EL PASO COUNTY GRADING AND EROSION CONTROL PLAN CHECKLIST

EPC Project Number: _____

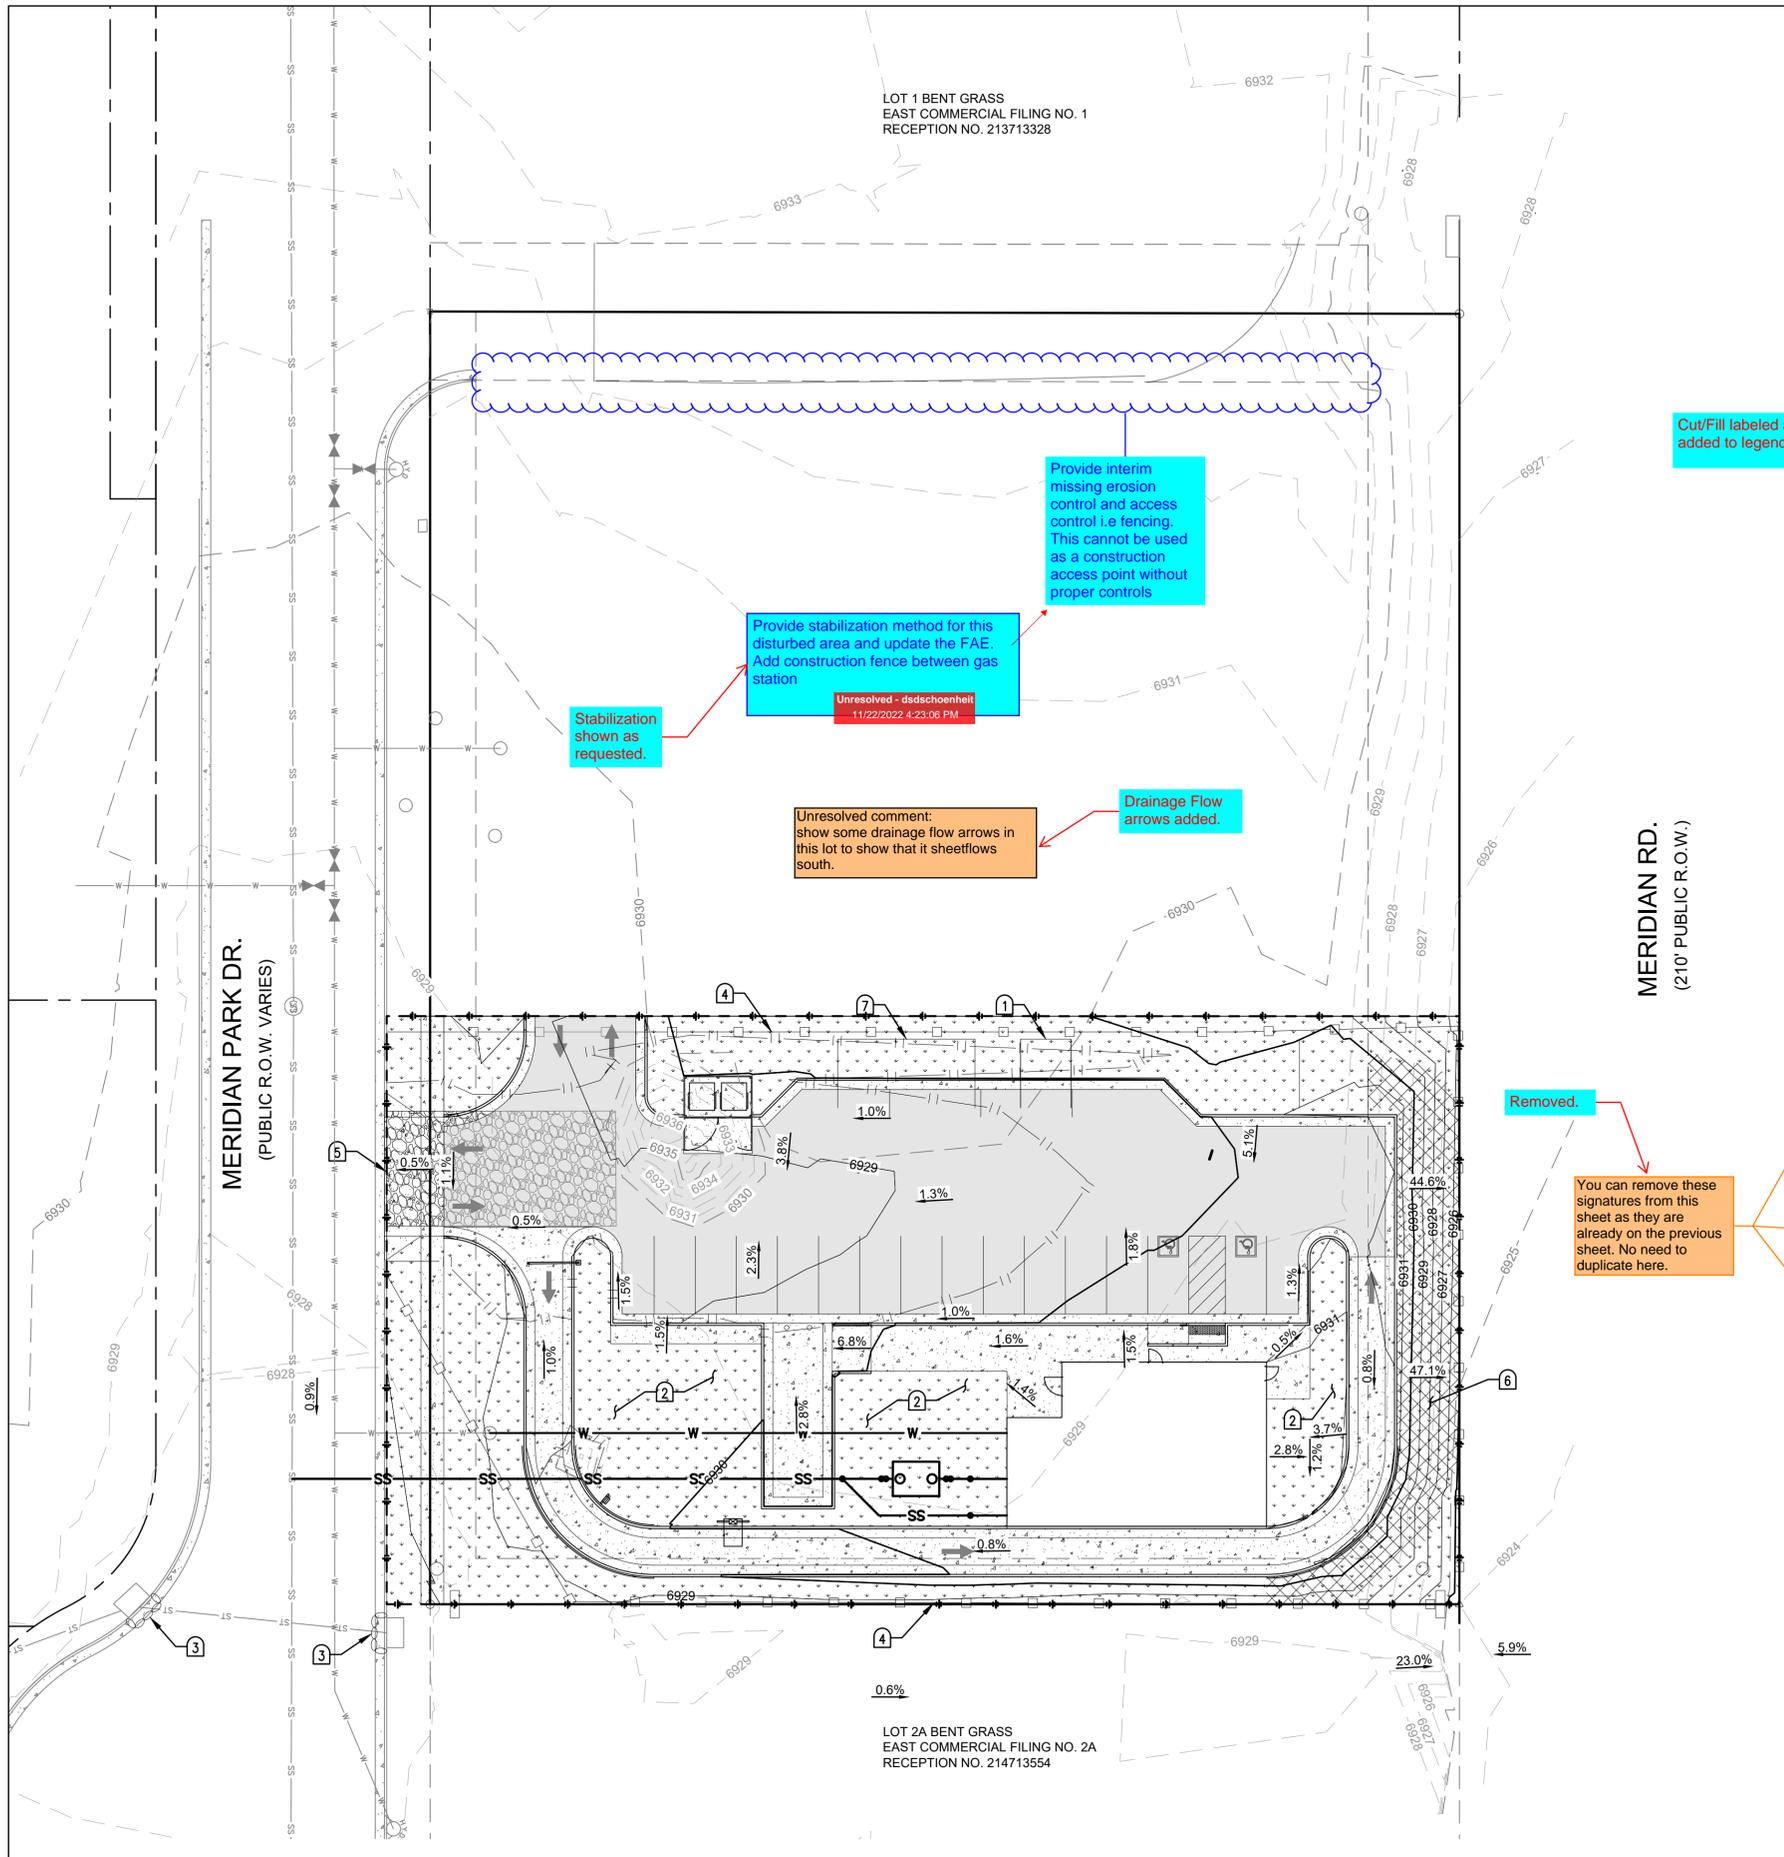
The GEC was submitted as a standalone doc so revise the signature blocks on sheet 2 to match those highlighted above.
